APPLICANT'S RESPONSE TO ISSUES RAISED AT DEADLINE 4

Drax Bioenergy with Carbon Capture and Storage

Document Reference Number: 8.10.4

PINS Reference: EN010120

PROJECT:	DRAX BECCS DCO				
TITLE:	FIGURE 1 LANDSCAPE AND BIODIVERSITY MITIGATION PLAN

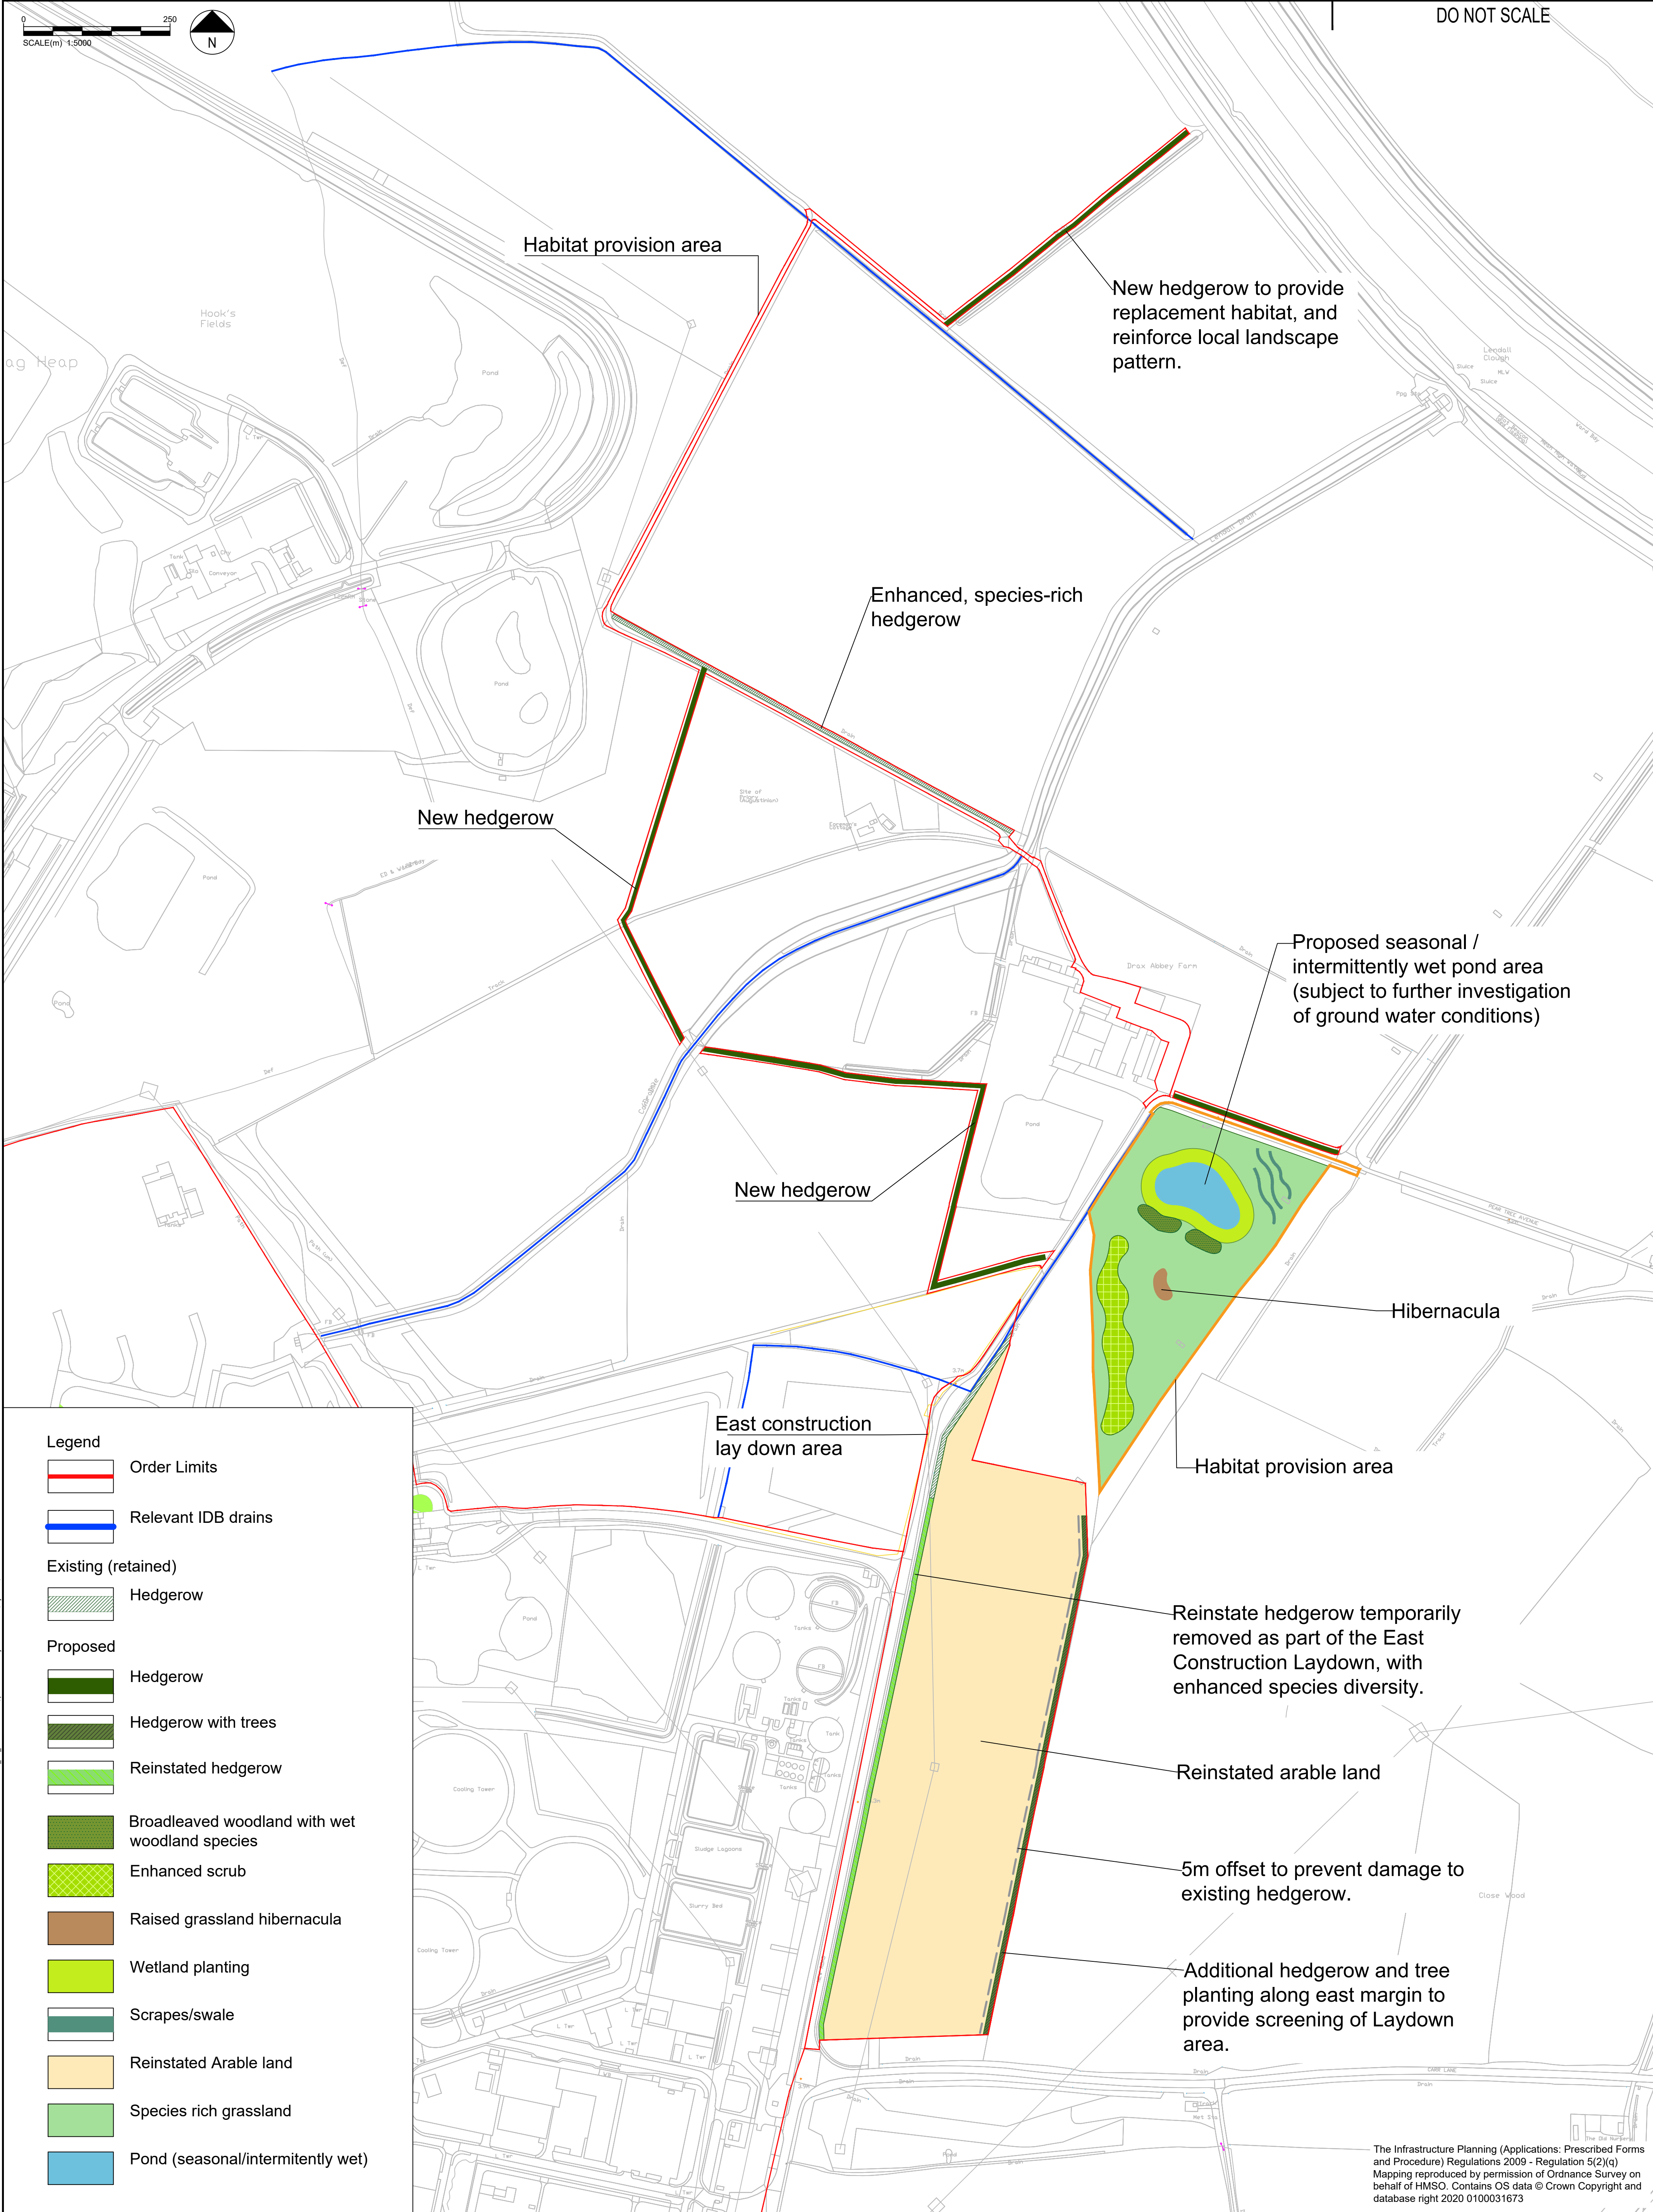
2.6	<p><u>Landscape Mitigation Plan</u></p> <p>The Outline Landscape and Biodiversity Mitigation plan (fig 1 in the OLBS) needs to include the whole of the Works area and not focus on the Habitat Provision Area. It is a concern to the Authorities that these plans imply that landscape mitigation and design will apply only to the habitat areas.</p>	<p>The OLBS (AS-094, updated at Deadline 5) sets out the landscape and ecological strategy for the whole of the Works area, including the Power Station site (Work nos. 1 and 2), the enabling works (Work nos. 3 and 4) and laydown areas (Work no. 5) and the habitat provision area (Work no. 6) – see OLBS Tables 2.1, 2.2, 5.1 and 5.2 for references to specific Work Numbers. Reference is made within the OLBS to the Design Framework (APP-195) in relation to the design principles to be adopted for the Scheme as a whole and specific Work Numbers. At this stage of the development, the detailed design is not sufficiently progressed for the main site (Work Numbers 1 and 2) to enable more detailed recommendations to be made beyond the design principles provided within the Design Framework, referenced within the OLBS. However, details for the design of the habitat provision area can be provided at this stage and have been set out within Figure 1 (Landscape and Biodiversity Mitigation Plan) of the OLBS (APP-181), as this will not be impacted by further design work or construction associated activity.</p>

Response Ref. (location in original submission)	Comment	Applicant's Response
		<p>Requirement 6 of the dDCO (REP2-007) requires accordance with item D1 of the REAC (REP3-007, Rev07 to be submitted at Deadline 5) which includes design principles to be adopted for Works Numbers 1, 2 and 3, and as described within Section 4 of the Design Framework (APP-195). These have been reviewed in light of the comments received at D4 from the Authorities in response to item 2.1 above.</p> <p>Requirement 7 of the dDCO requires a strategy to be provided for each phase of the scheme (work nos. 1, 2, 3, 4 and 7) as well as Work Nos. 5, 6 and 8, which is substantially in accordance with the outline landscape and biodiversity strategy. The requirement for a landscape and biodiversity strategy is not specific to numbered work 6.</p>
